From: Mark Warwick
Sent: 19 July 2018 15:29
To: Zac Denton
Cc: Planning.Responses
Subject: FW: Prior Notification Of Tree Works In A Conservation Area - AW/167/18/TC

I visited this location on July 18th 2018, to determine the aforementioned Town & Country Planning Act 1990 (as amended) s211 Notice.

Re: Tree Works Application at 34 The Drive, Bognor Regis

Location Plan

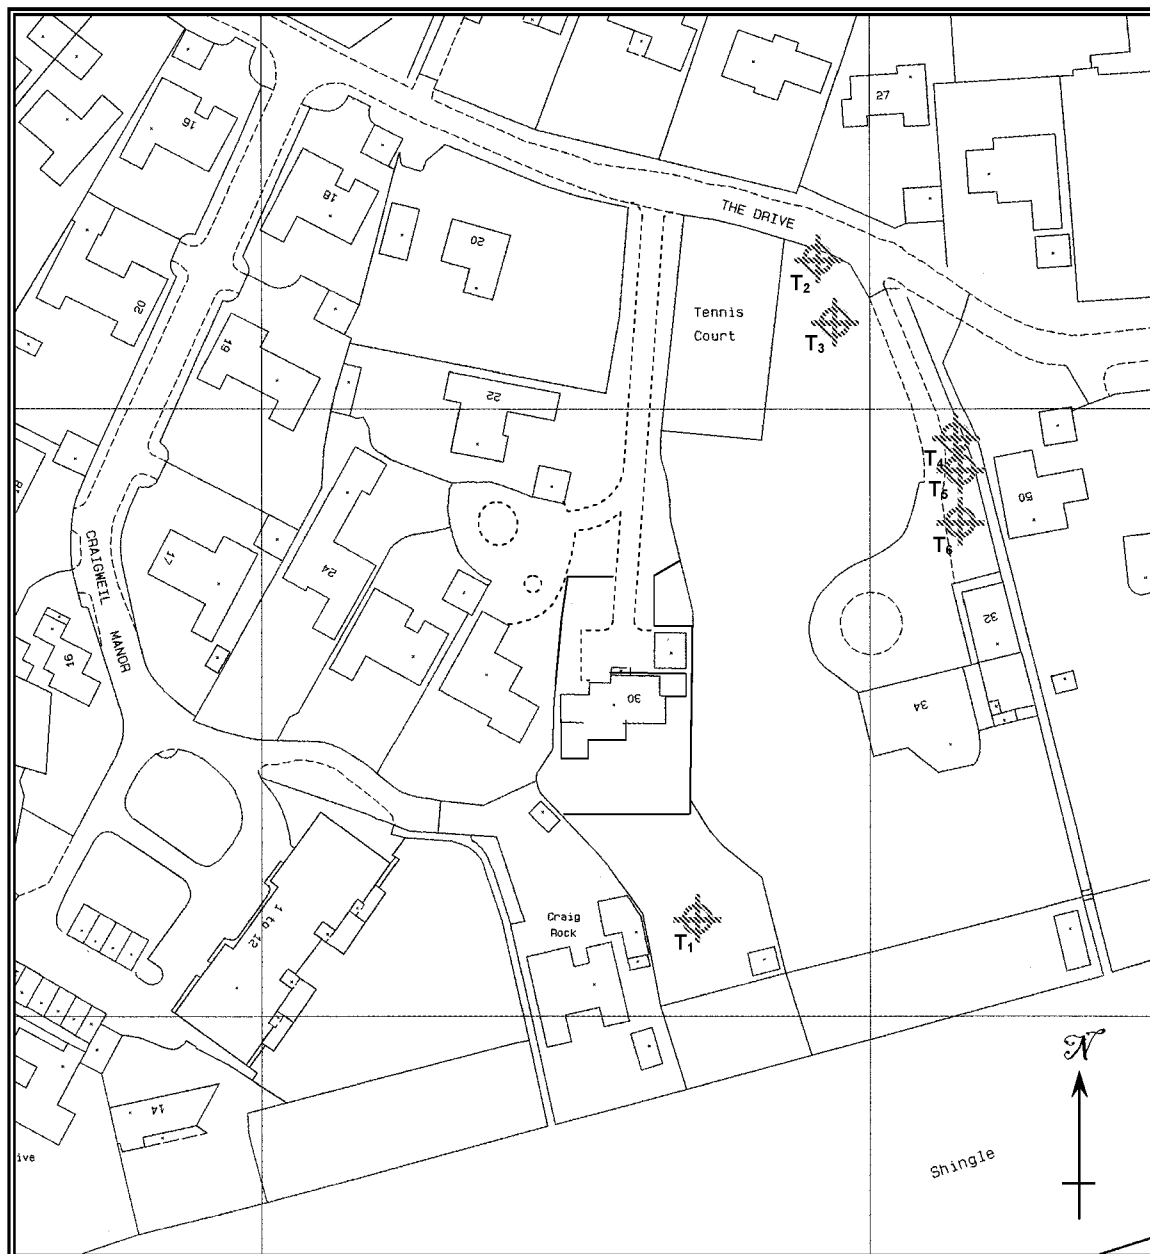
The sole exception being works proposed for T3 – Holm oak.

I saw no arboricultural justification for a crown reduction (3m height, 1m radial spread). This tree is worthy of an Order (TPO) to control its management and prevent a loss of amenity value.

The applicant has accepted my suggestion of a much lesser tree work operation (as described below), which would involve the removal/reduction of low branches to achieve 4m overhead clearance above understorey ornamental shrubs. This latter operation will not impact on the overall height and spread of the tree (as initially proposed) and preserve its amenity value.

Further to your inspection we no longer wish to carry out the proposed works to Holm Oak (T3) and will instead crown lift 4m all aspects.
